WEST SUSSEX COUNTY COUNCIL
PREAPPLICATION CONSULTATION

TO: Mr Simon Arch
FROM: Ian Hayward
SUBJECT: PRE-266-16
Residential redevelopment for one dwelling
Church Farm House, Binsted Lane, Arundel, West Sussex, BN18
OLN

RECOMMENDATION: Advice

BLOCK PLAN 1:500

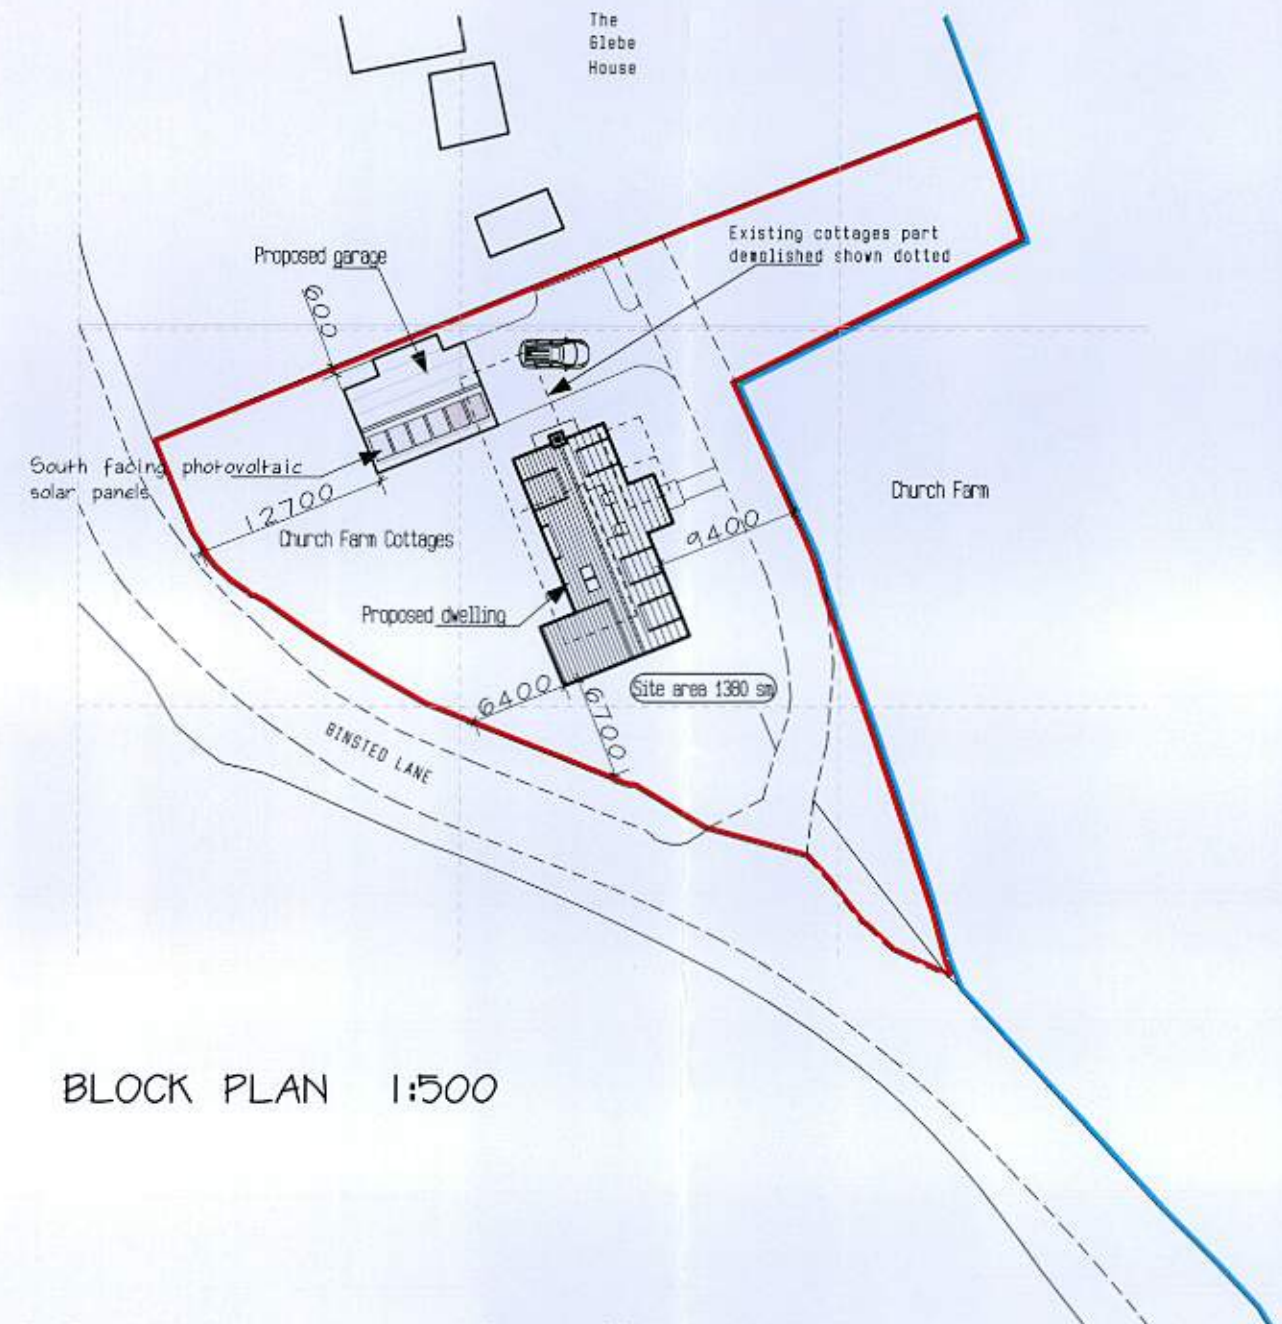
On site it was observed that visibility in the northern direction at this point of access was substandard. Improvements to visibility could be achieved, though this would require significant landscaping, hedgerow relocation works. Consideration is given to the history of the site and principle of the application, which does not seek a material intensification of use at the access point onto the maintained highways network. Given the history of the site the Highways Authority would not be minded to raise any highway safety or capacity concerns to the principle of the proposal.

Any residential dwelling proposed should be provided an off street car parking provision to meet the needs of the development. I can advise that a dwelling of this size in this location would attract a minimum demand for two off street car parking spaces. These should measure 2.4 x 4.8 metres if provided on a hardstanding or 3 x 6 metres if provided within a garage. Secure and covered cycle parking should also be provided to support local and national sustainable transport policies. Garages as described above can

Providing a turn on site would be considered ideal, but consideration is given that a layout could be provided that allowed the private access drive to be used to facilitate a turn on site in order to enter Binsted Lane in the forward gear.
